Consultation Response from: KC Environmental Health (Pollution & Noise Control)		
2023/91463 - Chai Shai, 4A Albion Street, Batley, WF17 5PS		
Erection of cafe		
Responding Date: 24 August 2023	Responding Officer: Mohammed Nasim	Responding Ref: WK202325257
<p><u>Comments</u></p> <p><u>Noise</u> There is potential for noise from the proposed site to affect the amenity of neighbouring properties. A condition for a Noise Management Plan to be submitted is recommended. The plan shall detail the control measures that will be taken to ensure that excessive noise does not arise from the use of the premises. This includes but is not limited to noise from customers, deliveries/collections/waste disposal etc.</p> <p><u>Cooking Odours</u> There is potential for cooking odours from the proposed site to affect the amenity of neighbouring properties. A condition for an odour assessment to be submitted is recommended.</p> <p><u>Kitchen Drainage</u> A condition is recommended for a scheme to prevent fats, oils and grease entering the drainage network serving commercial food preparation and dish-washing areas to be submitted.</p> <p><u>Contaminated Land</u> The site is adjacent to potentially conta

Drawing:
Proposed Elevations

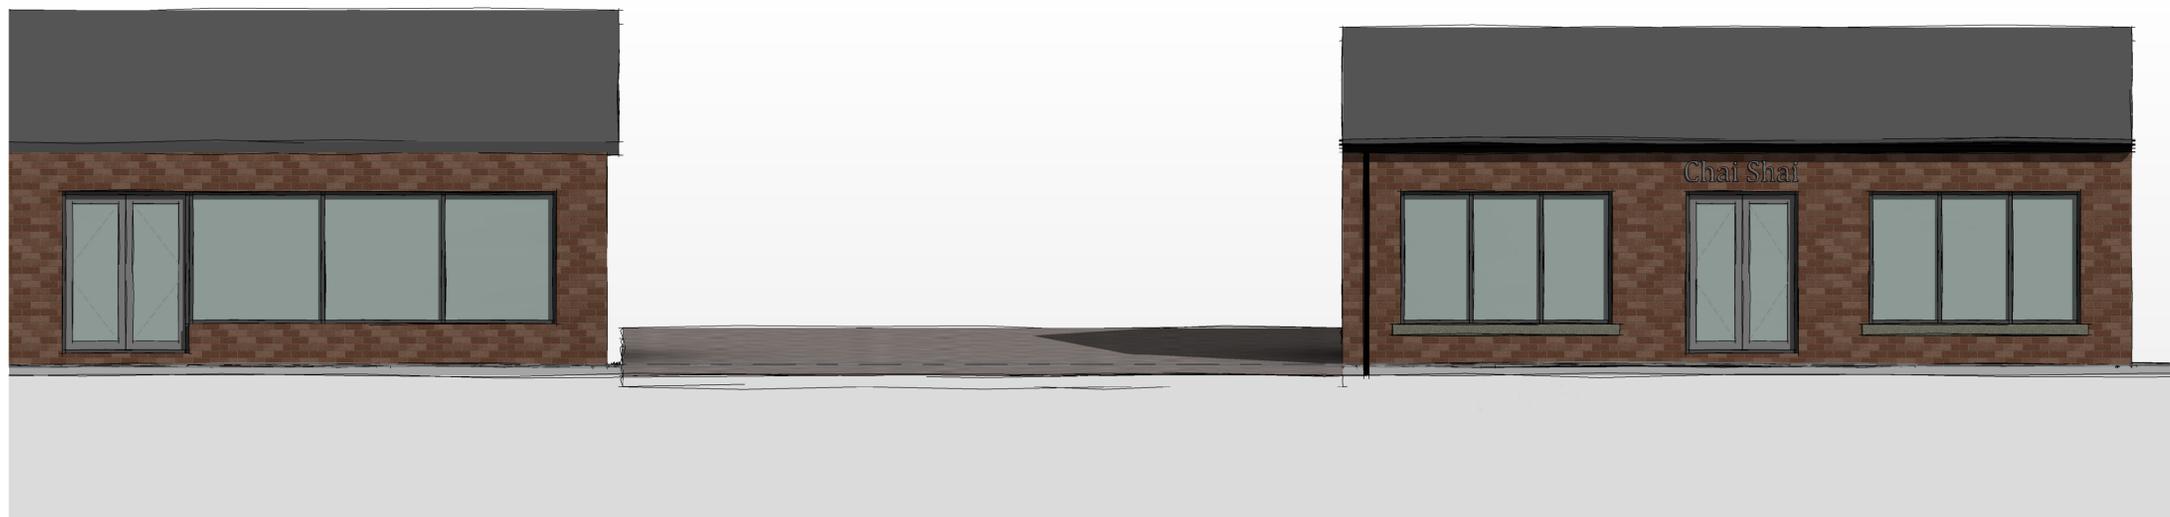
Elevations does not allow for this. The applicant is notified that if smoking is permitted on the premises, it must be compliant with the smoke-free legislation as set out in Section 2 of the Health Act 2006 with regards to the construction of the structure. Premises will be considered to be enclosed if they have a ceiling or roof and, except for doors, windows or passageways, are wholly enclosed, whether on a permanent or temporary basis.
